October 29, 2025
Development Facilitative Team (DFT)
600 2nd St NW, Albuquerque, NM 87102

RE: Project: PR-2022-007565; SP2025-00075- SITE PLAN DFT Comment responses

To whom it may concern,
I am in receipt of comments provided on 10/22/2025 and have provided the following revisions, and responses to those comments:

AS102

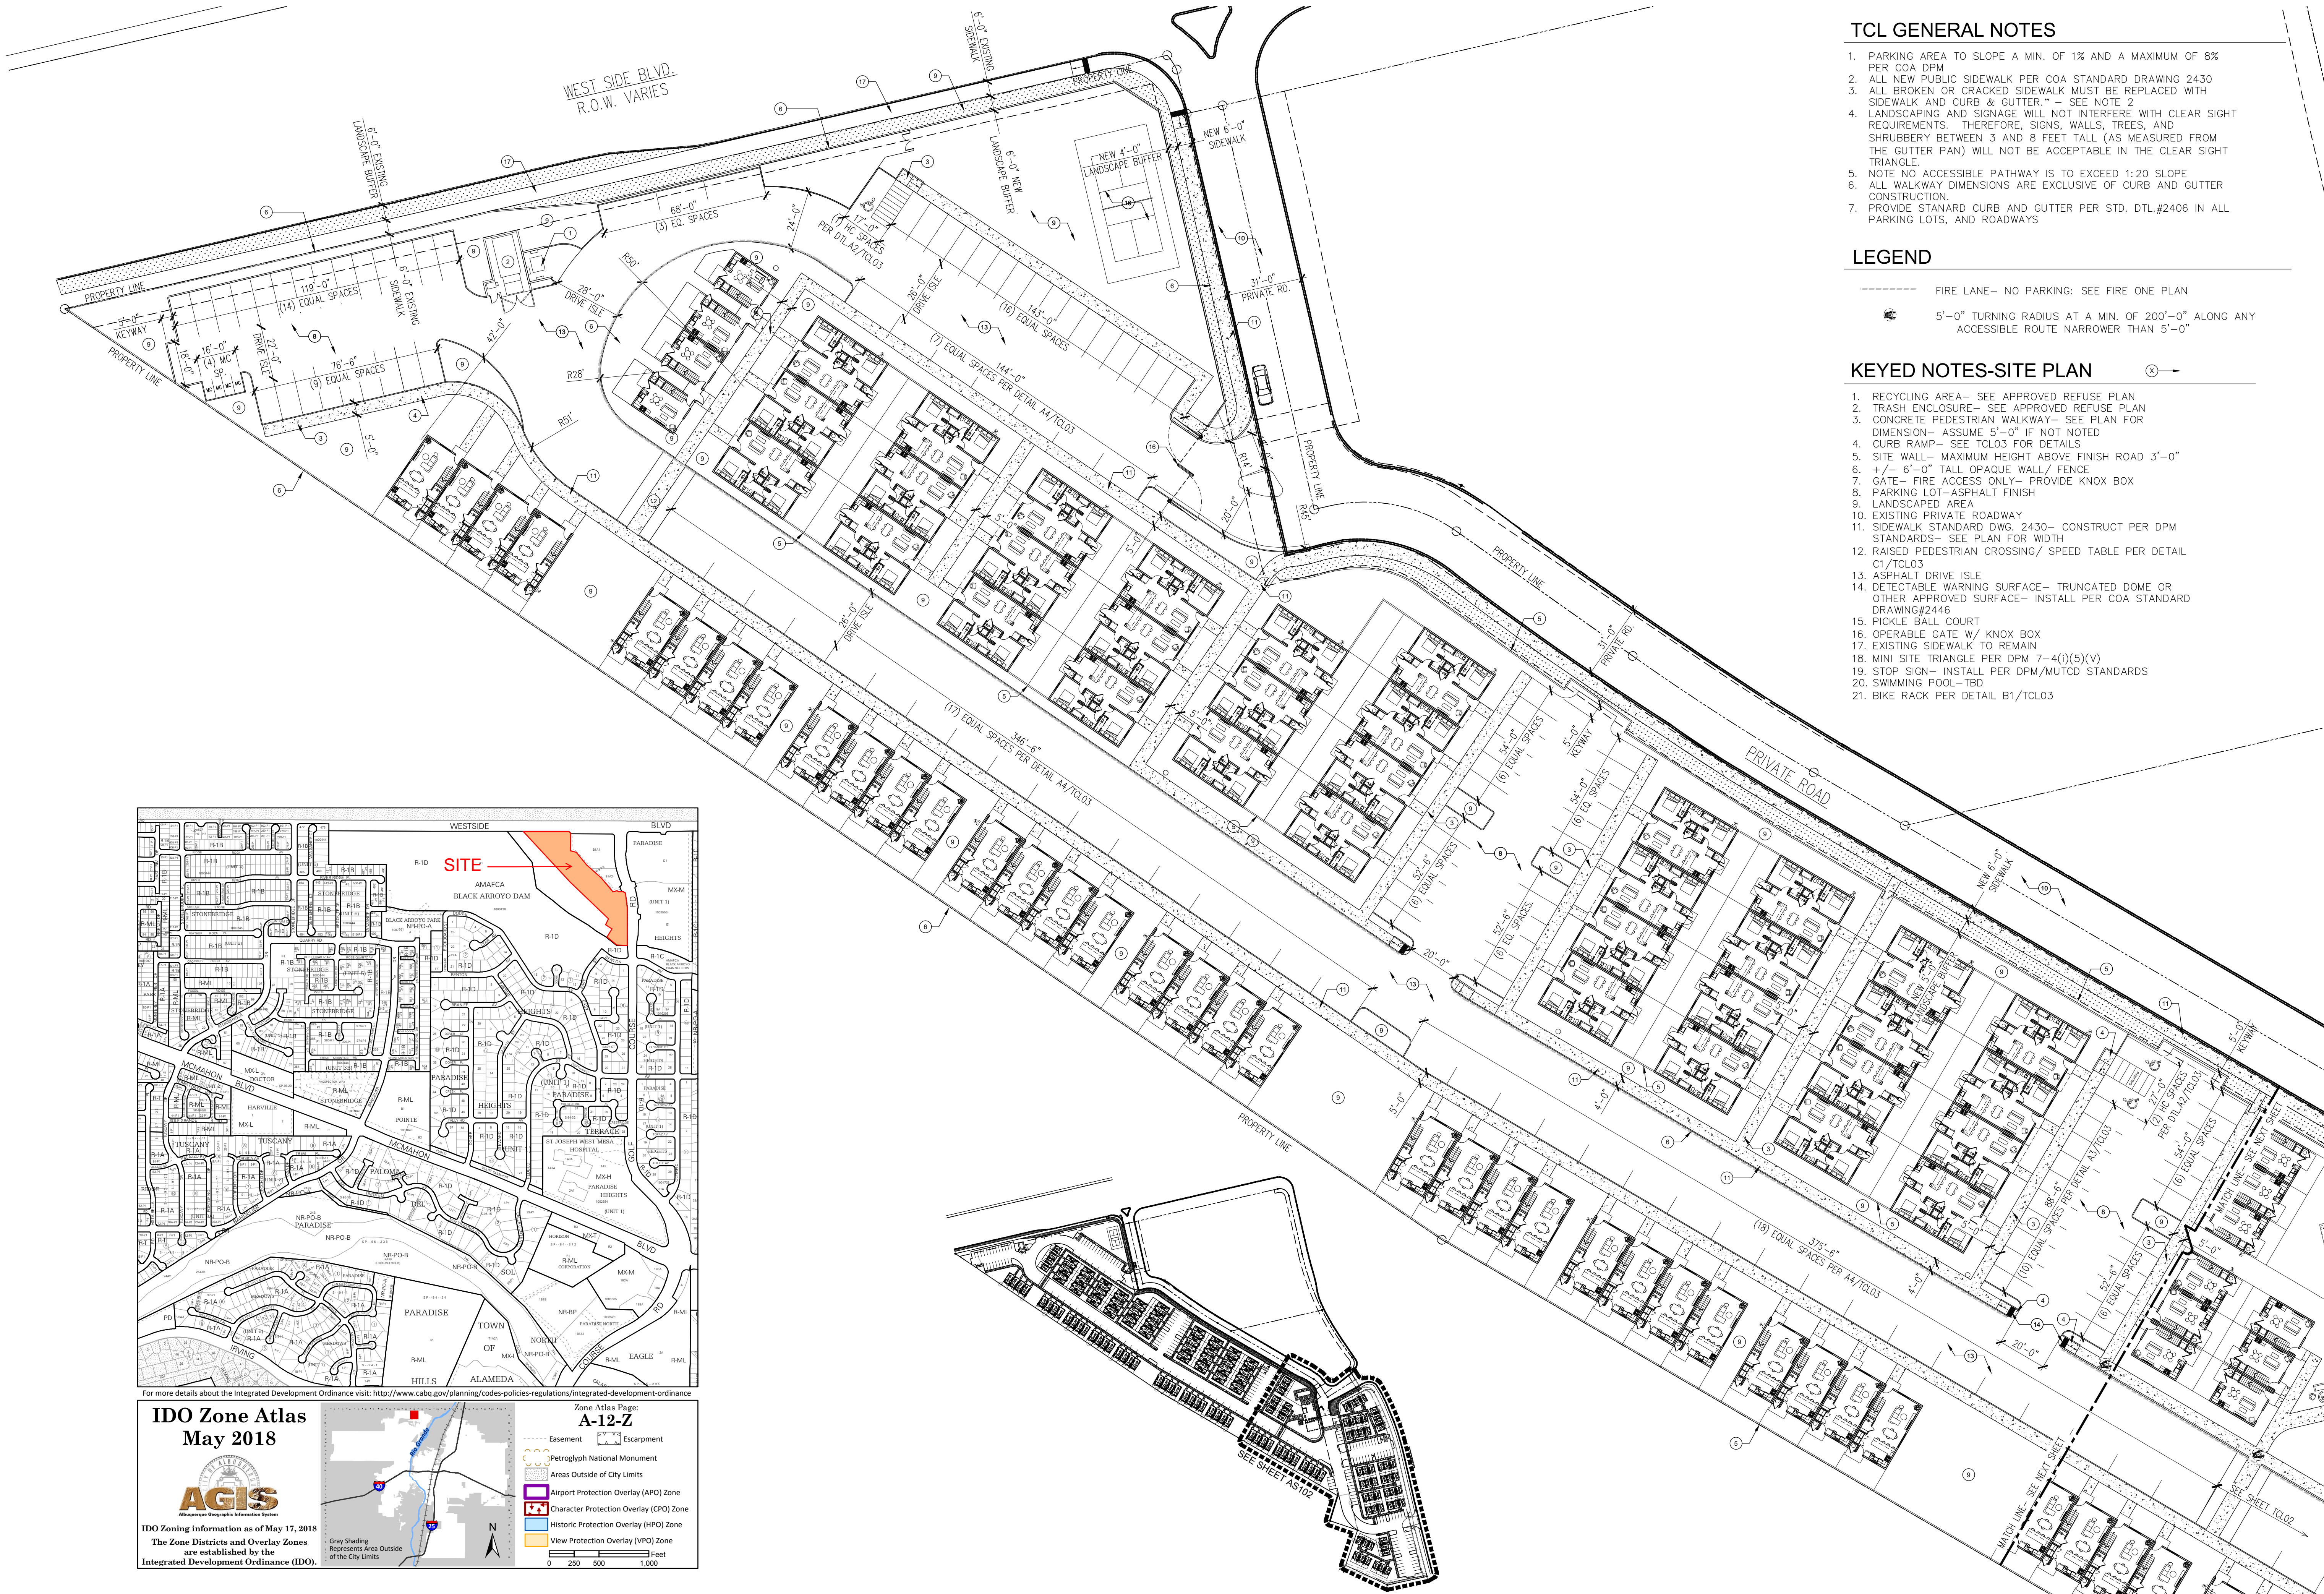
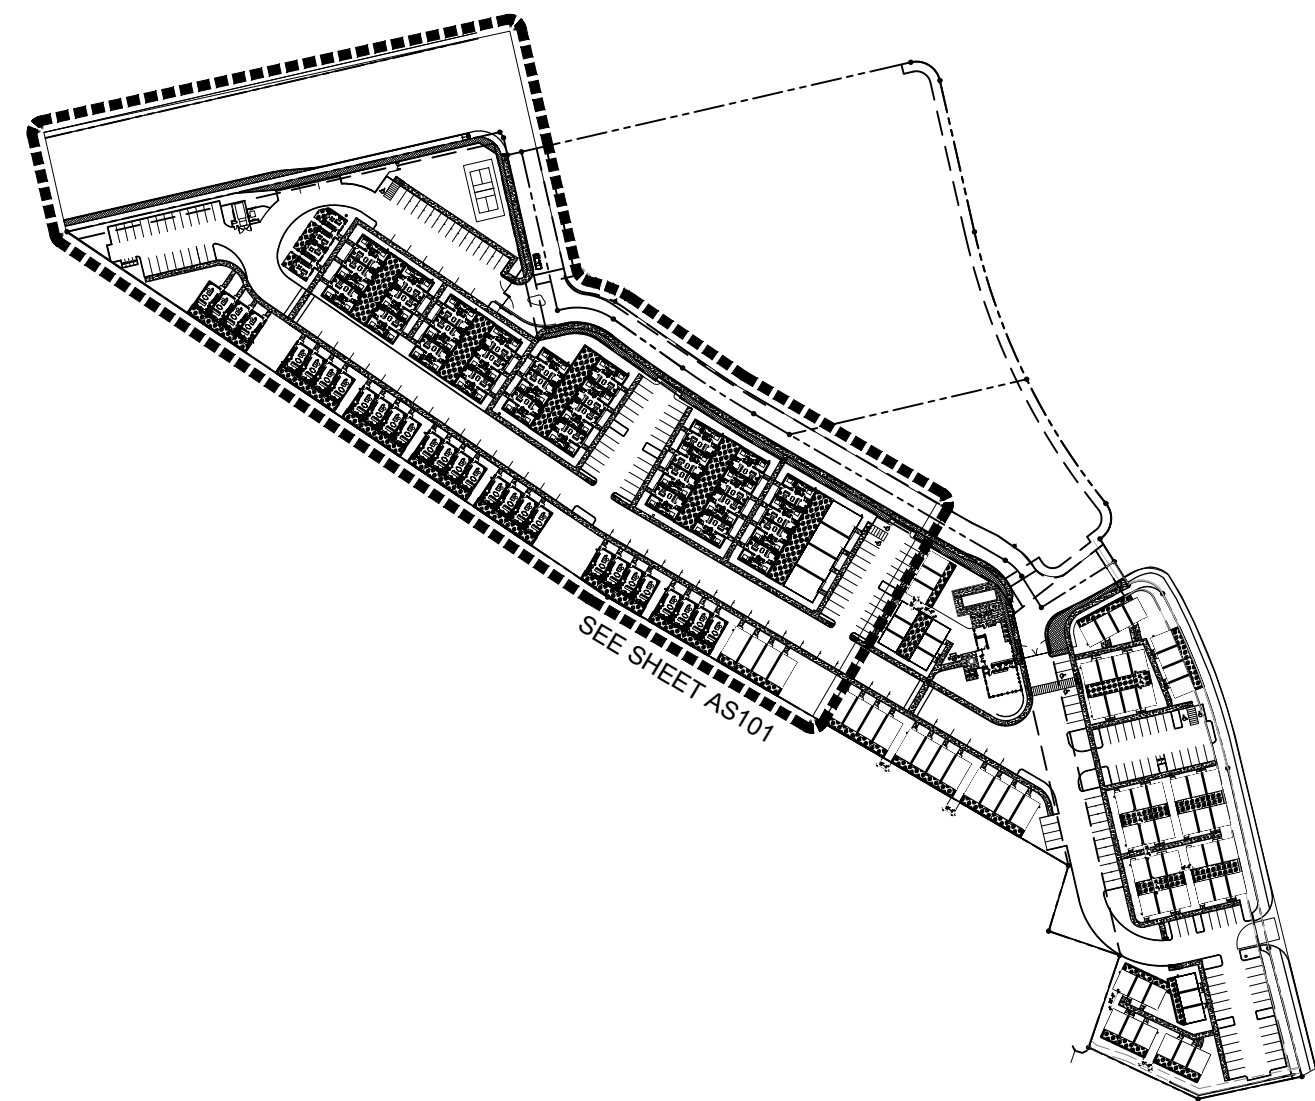
1. Wall along Westside is shown as a 6-foot opaque wall. However, the wall height is limited to 3 ft in height in front yard setback, as per IDO 5-7(D) Table 5-7-1, or up to 4 feet on the front parking lot edge as meeting a parking lot buffer requirement, as per IDO 5-6(F)(1)(i).

2. Parking spaces along Westside require parking lot buffer wall, as noted above, or will require a 10-foot landscape buffer, as per the same section, IDO 5-6(F)(1)(i). This is cited in the Landscape Plan note #9, but it does not appear to be implemented

Response: Site plan has been revised to show a 4'-0" screen wall along the front parking lot edge. This wall will provide the required parking lot buffer as indicated in Comment #2.

Response: A 4-foot tall parking lot screen wall will be used for in lieu of the 10-foot landscape buffer referenced.
3. Lighting: Light fixtures, IDO 5-8(E): General Design and Illumination Standards. Provide documentation showing how requirements are being met:

A1 TYPICAL REFUSE ENCLOSURE DETAILS  
1'-0"=50'-0"

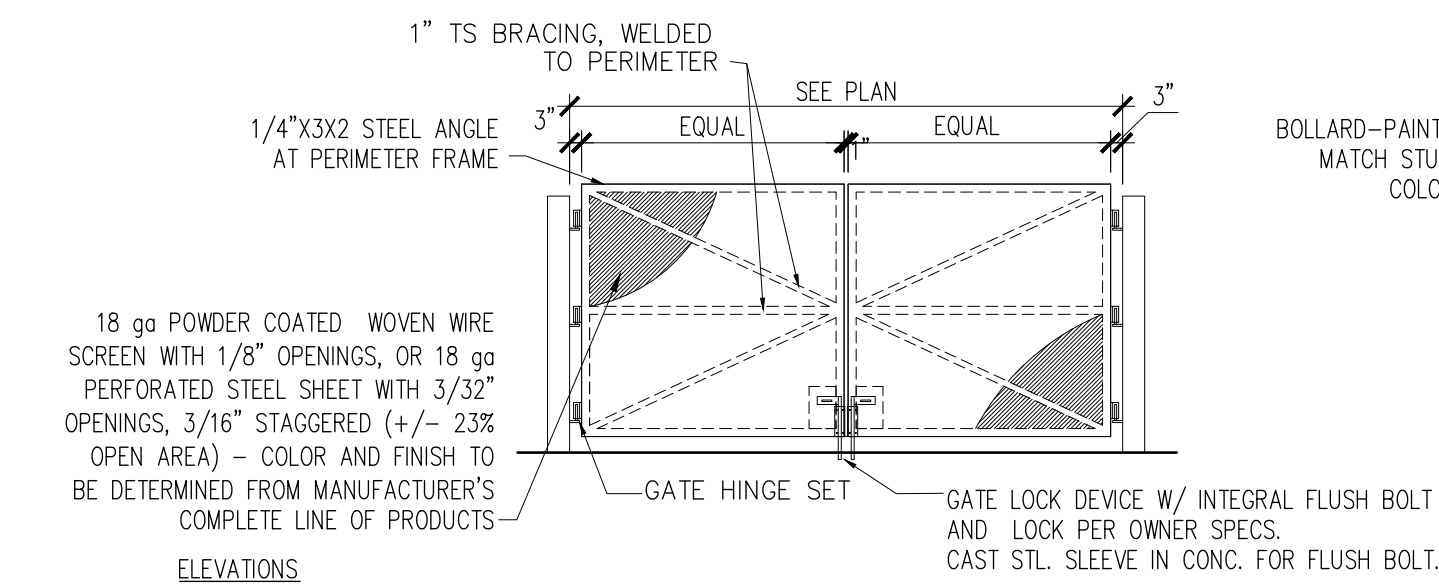
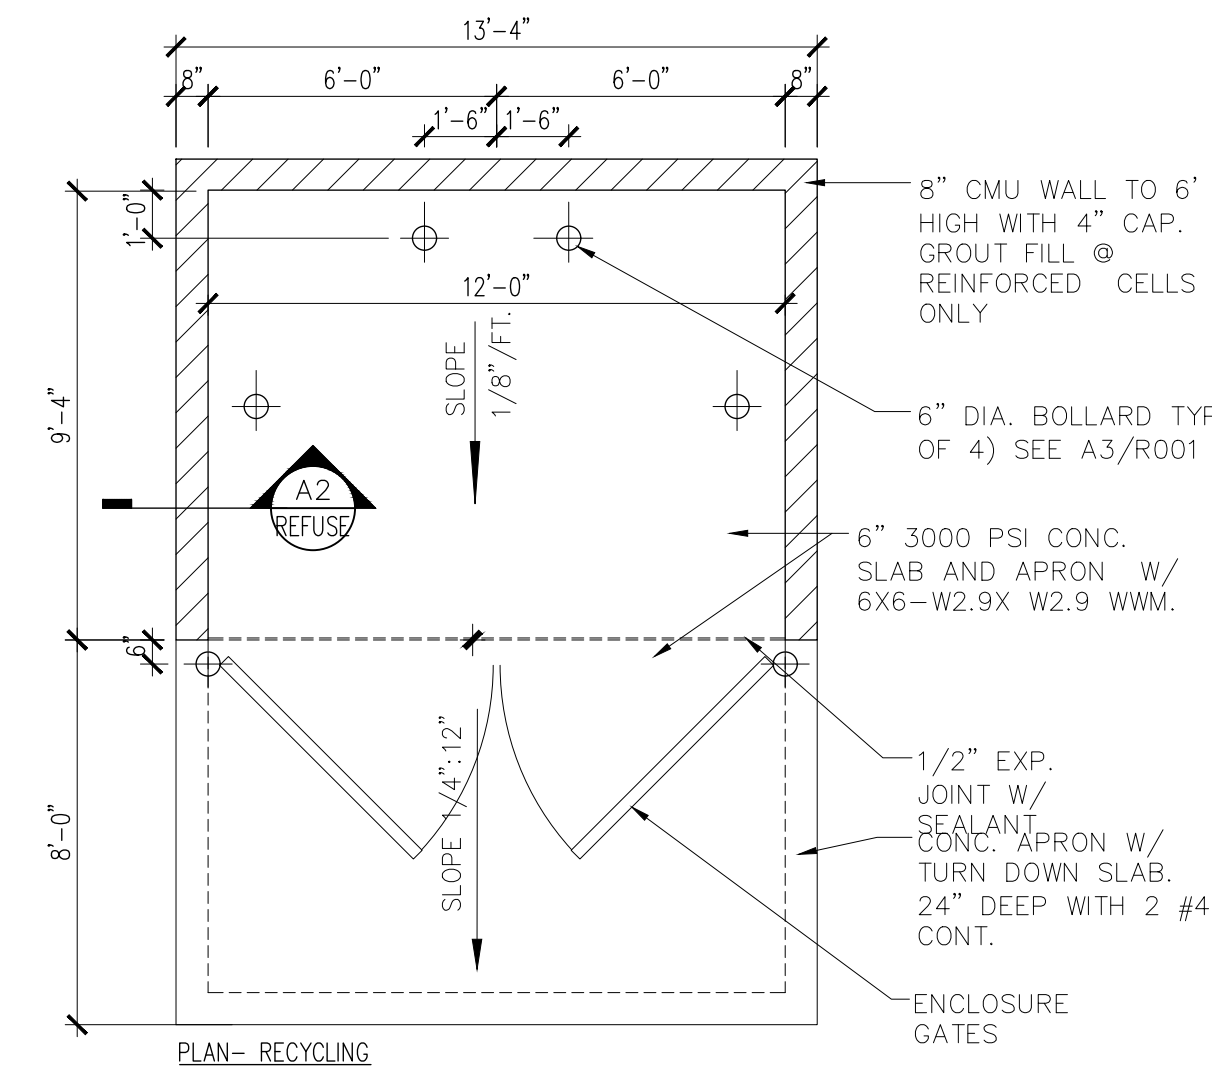
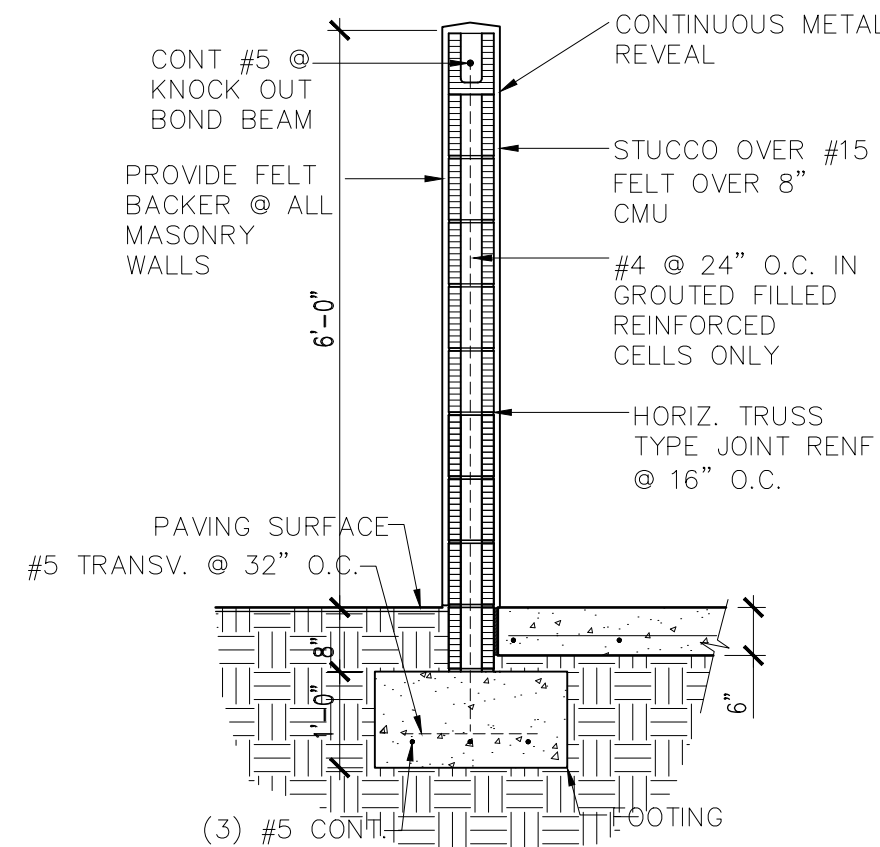
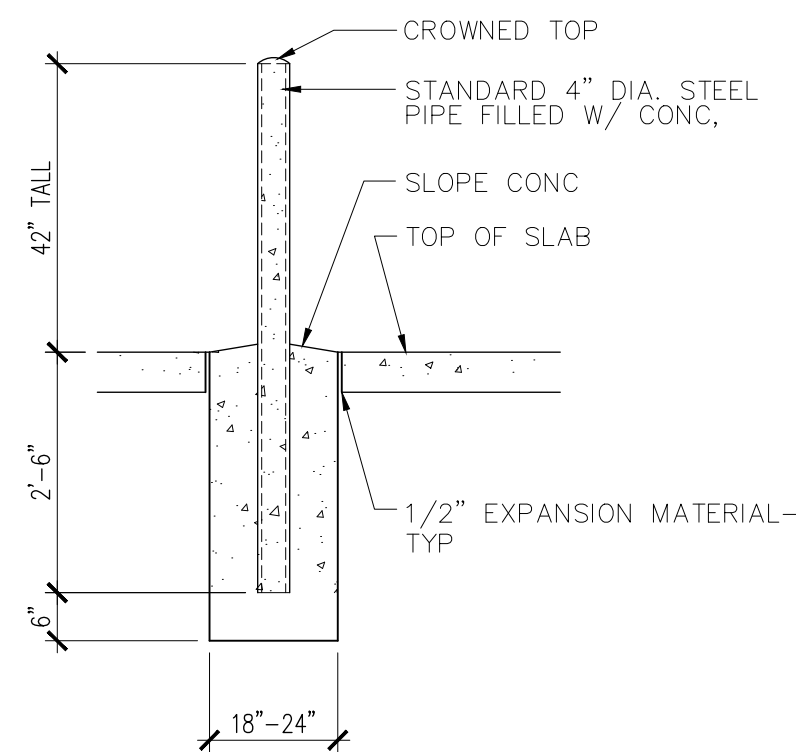
- b. Loading Service and Refuse areas.

Response: The project will provide a compactor as approved by the solid Waste Department. The compactor will be screened with a 6'-0" stucco enclosure as detailed on sheet R001.
